Planning Application No: 3/2024/0612

Proposal: Proposed change of use and conversion of single-storey garage/workshop to two storey, two-bedroom holiday let including new dual pitch roof.

Location: Land opposite Turner Fold Read BB12 7QZ

Tahira Akhtar BA (Hons)
Technician
Highways and Transport
Lancashire County Council

DRAWING TITLE:  
**VISIBILITY PLAN**

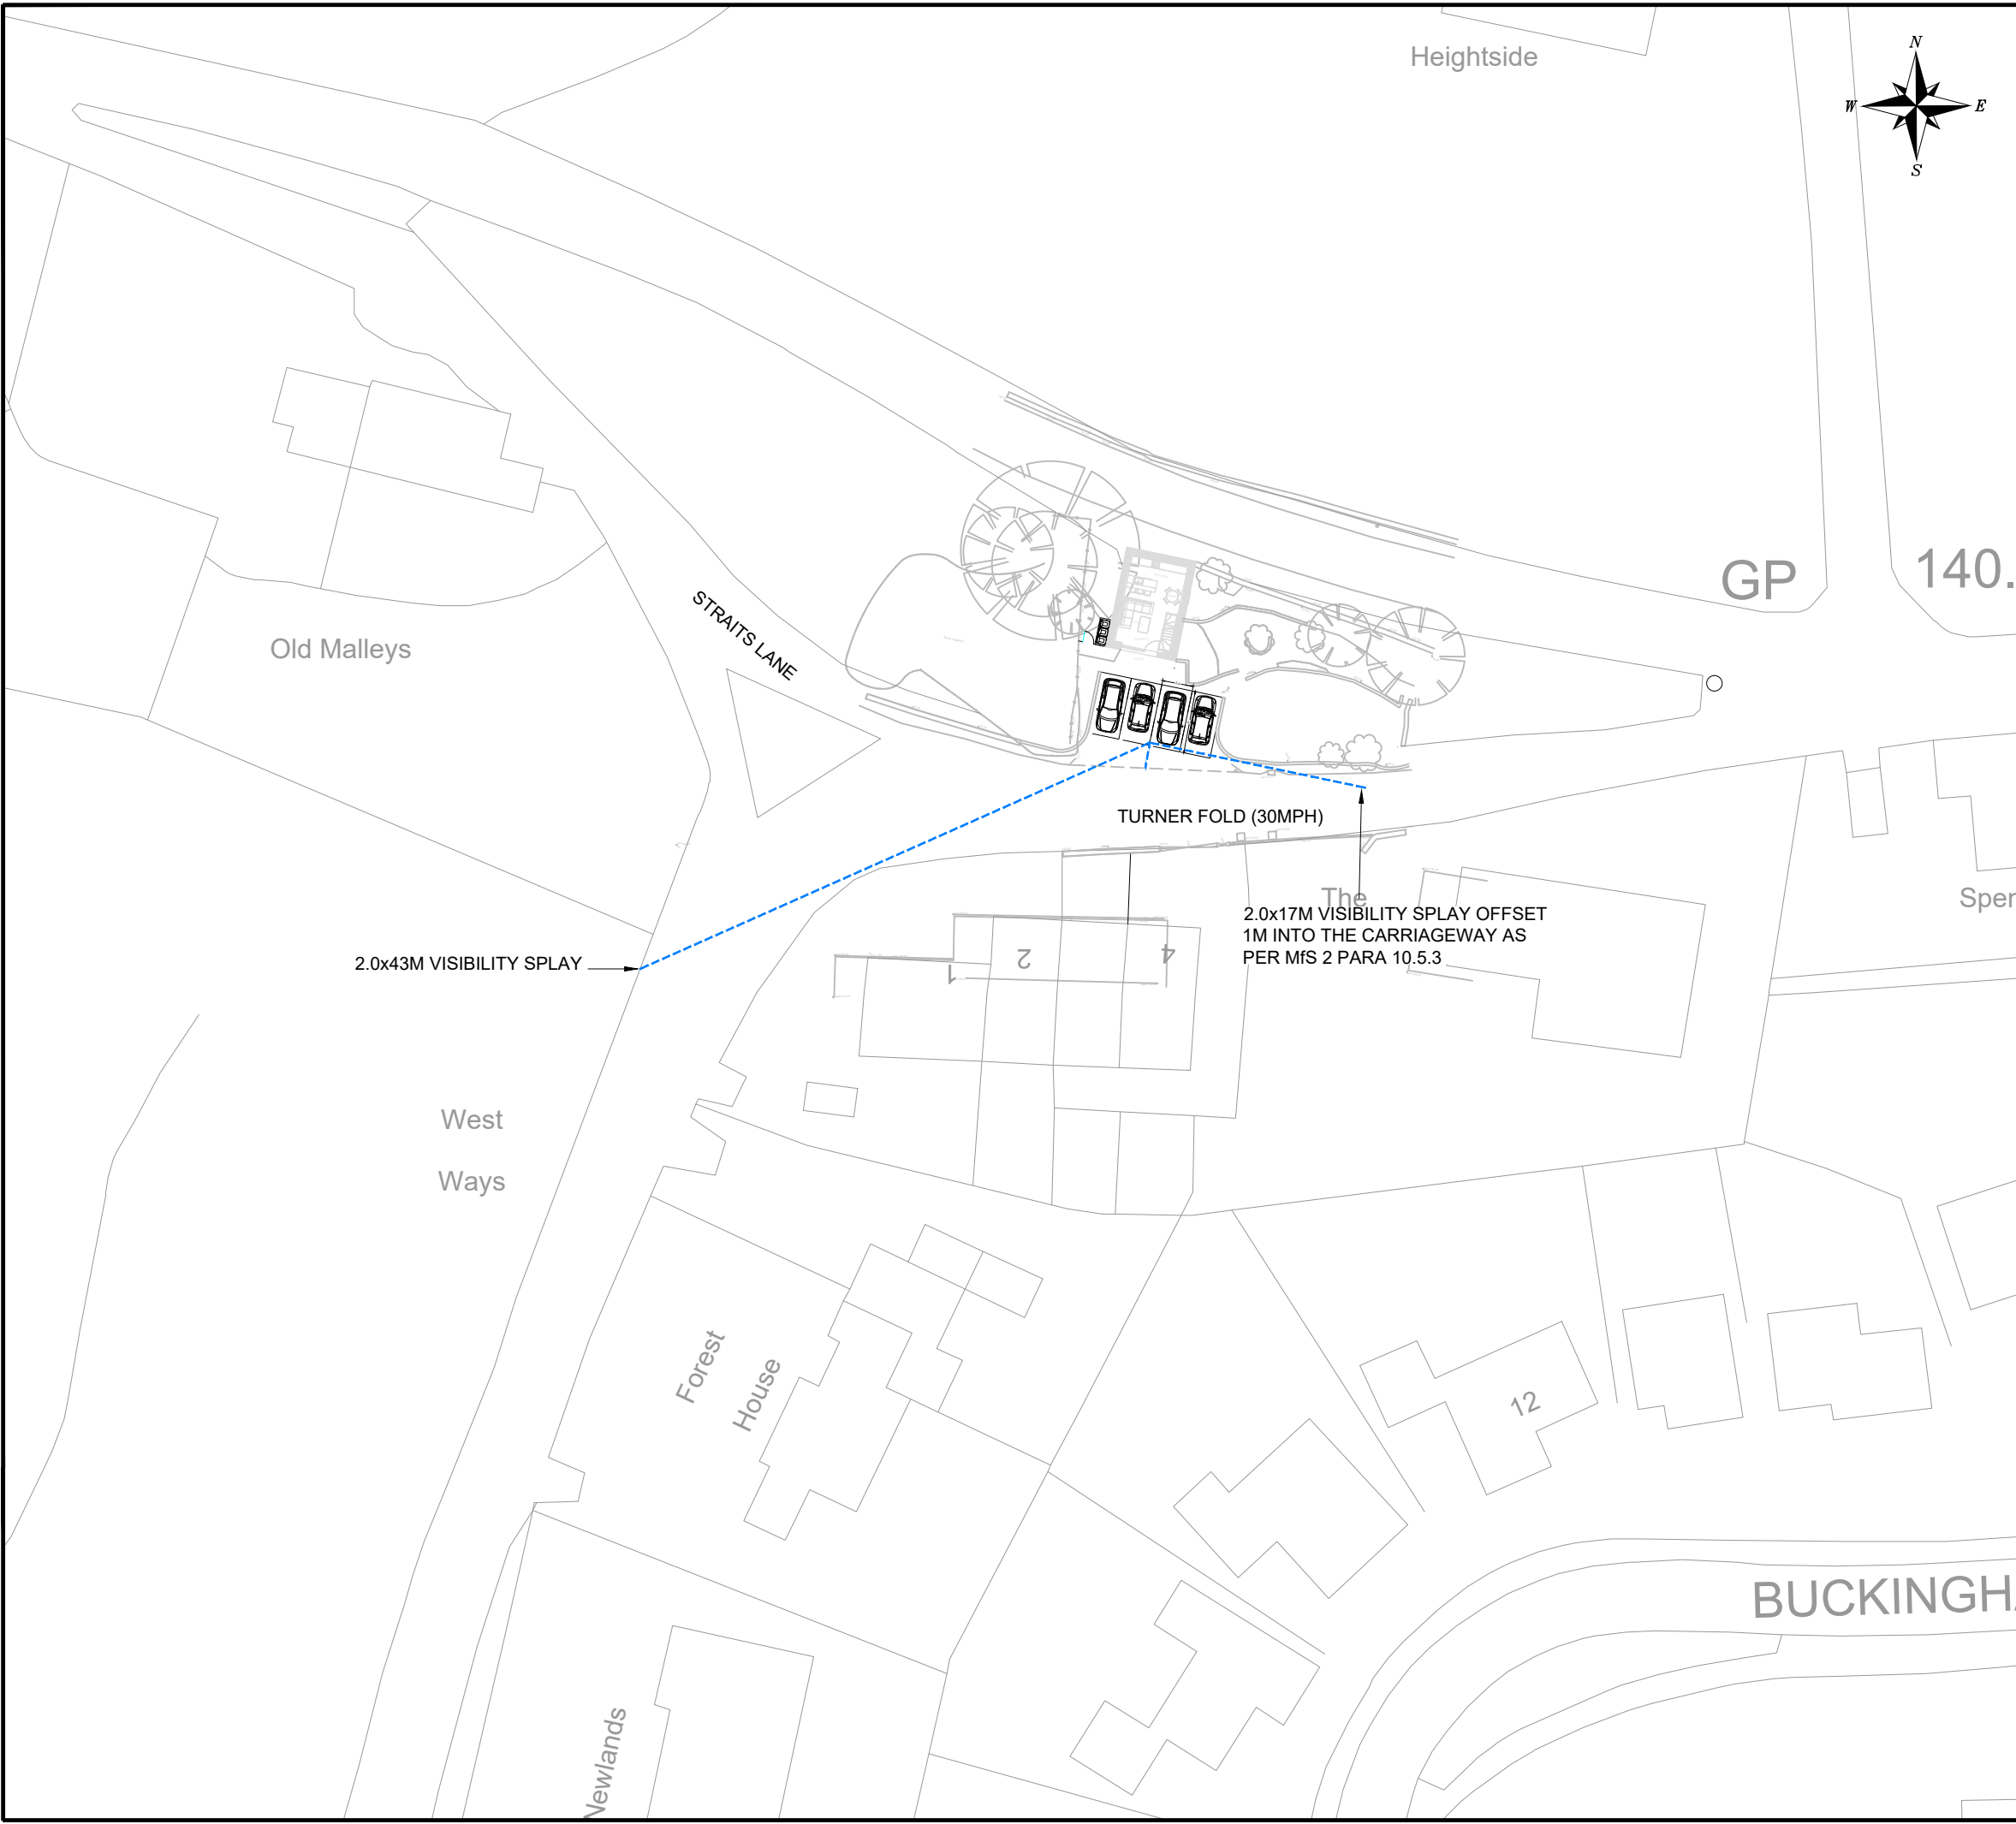
To ensure highway safety, a visibility drawing is required with the splays for the 30mph speed limit – 2.4m by 43m to both sides. Everything in the splays is required to be reduced to below 1m.
